14-15. LINK BETWEEN WRE/TSF MANAGEMENT AND GROUNDWATER ASSESSMENT

Concern:

Figure 7 –WRE cells layout.

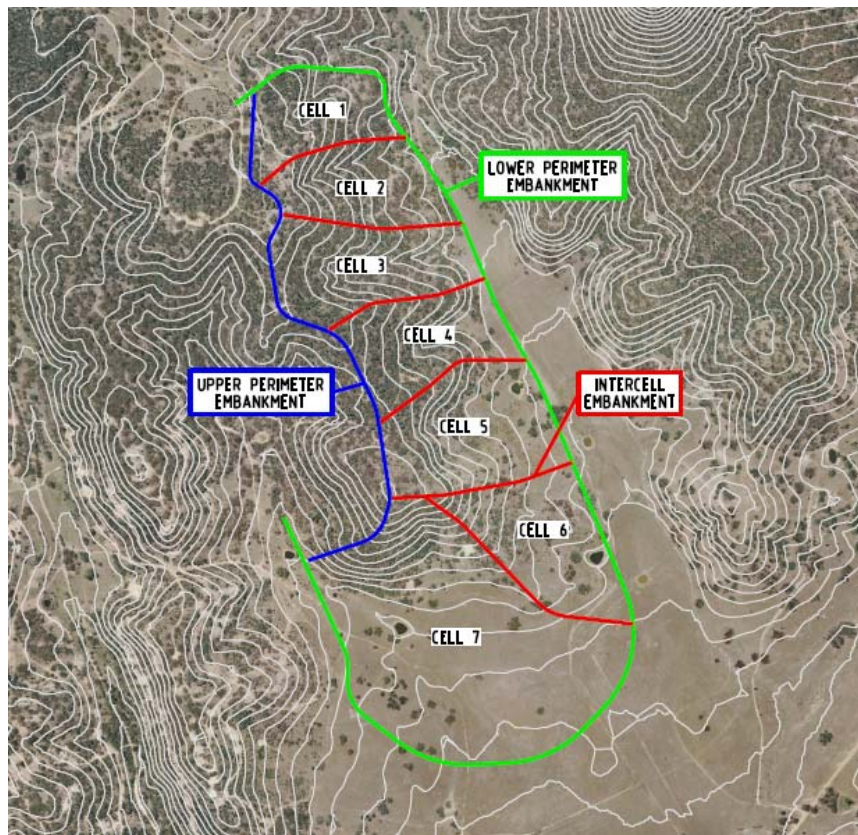
Similarly, the leachate management dam and sumps designed to capture leachate from the ~22 million tonnes of potentially acid forming (PAF) waste rock do not consider the presence of faults. Figure 2 indicates that the throw on this fault may be hundreds of metres.

Figure 17 – Ultimate leachate management dam.

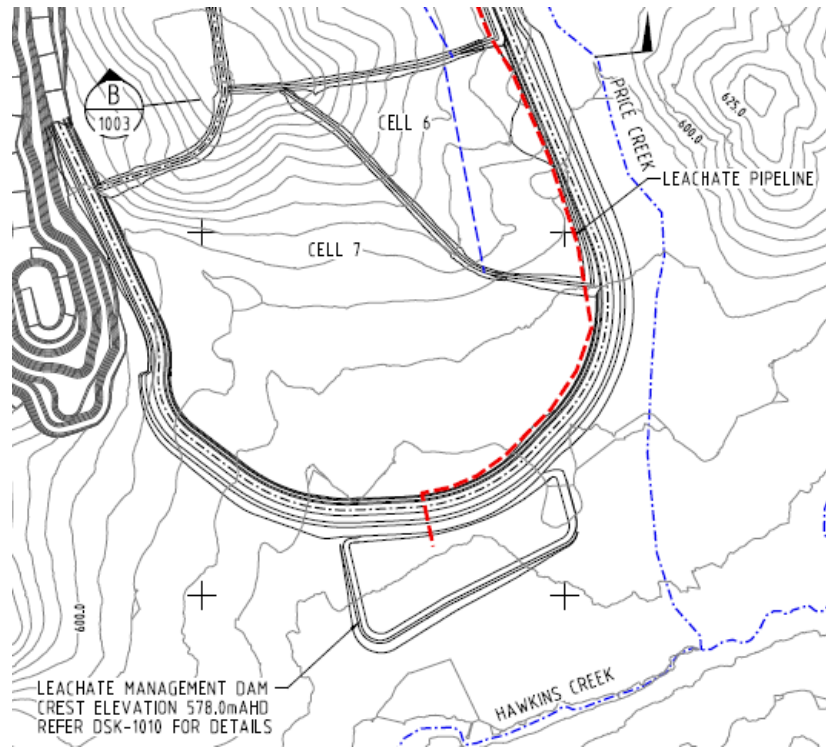
An appropriate resolution groundwater contour map post mining, 50 years post mining and 130 years post mining would help confirm the groundwater flow gradients around the pit lake and beneath other key site infrastructure such as the TSF and leachate management dam. Particle tracking using the groundwater flow model or a solute transport model would also confirm that potential seepage from the TSF and WRE reports to the pit lake.
